Our Ref: BR/120/18/PL

**Town & Country Planning Act 1990 (as amended)
Town and Country Planning (Development Management Procedure) (England) Order 2015
Application for Planning Permission**

Development Conversion of existing ground floor flat into 3 No. self-contained apartments.
Location 2 Highfield Road Bognor Regis

PROPOSED ELEVATIONS

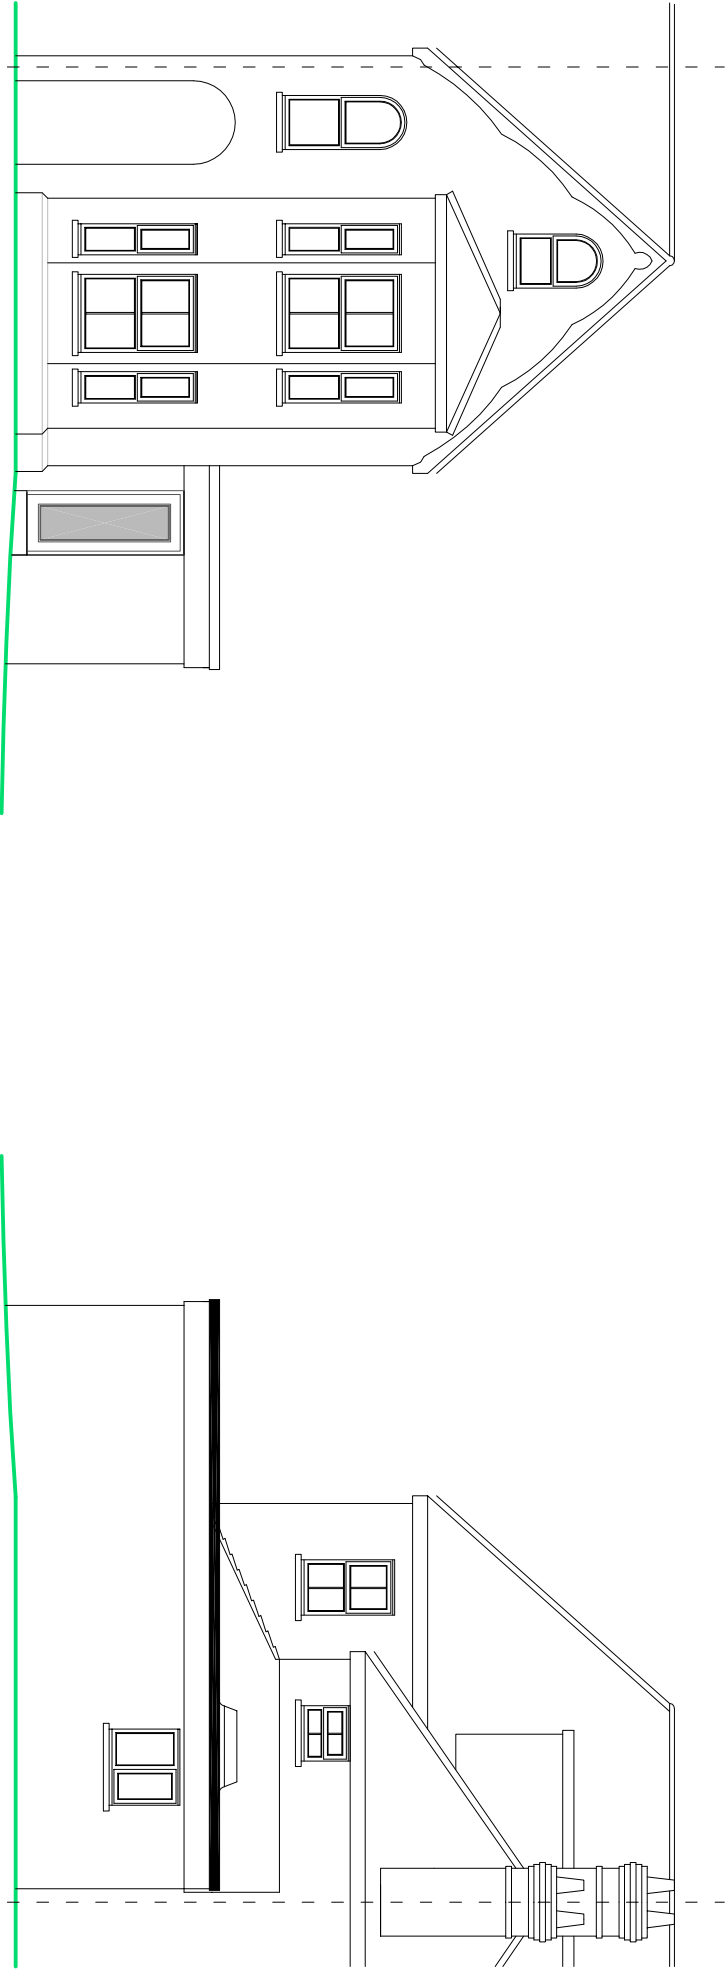
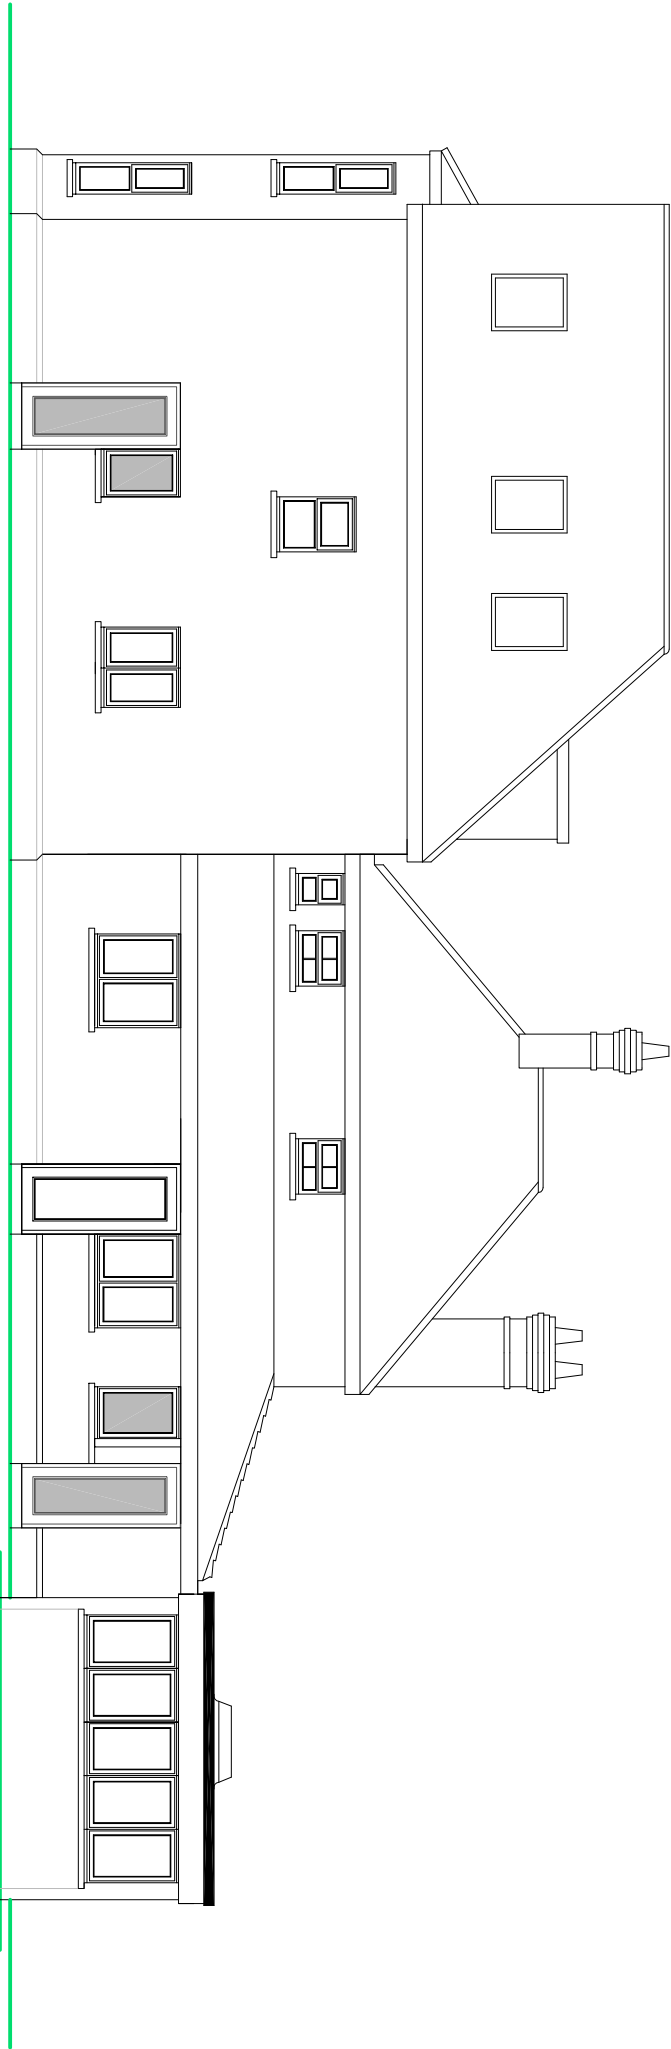
Two sets of proposed elevations has been submitted. Please relabel one of the plans as existing.
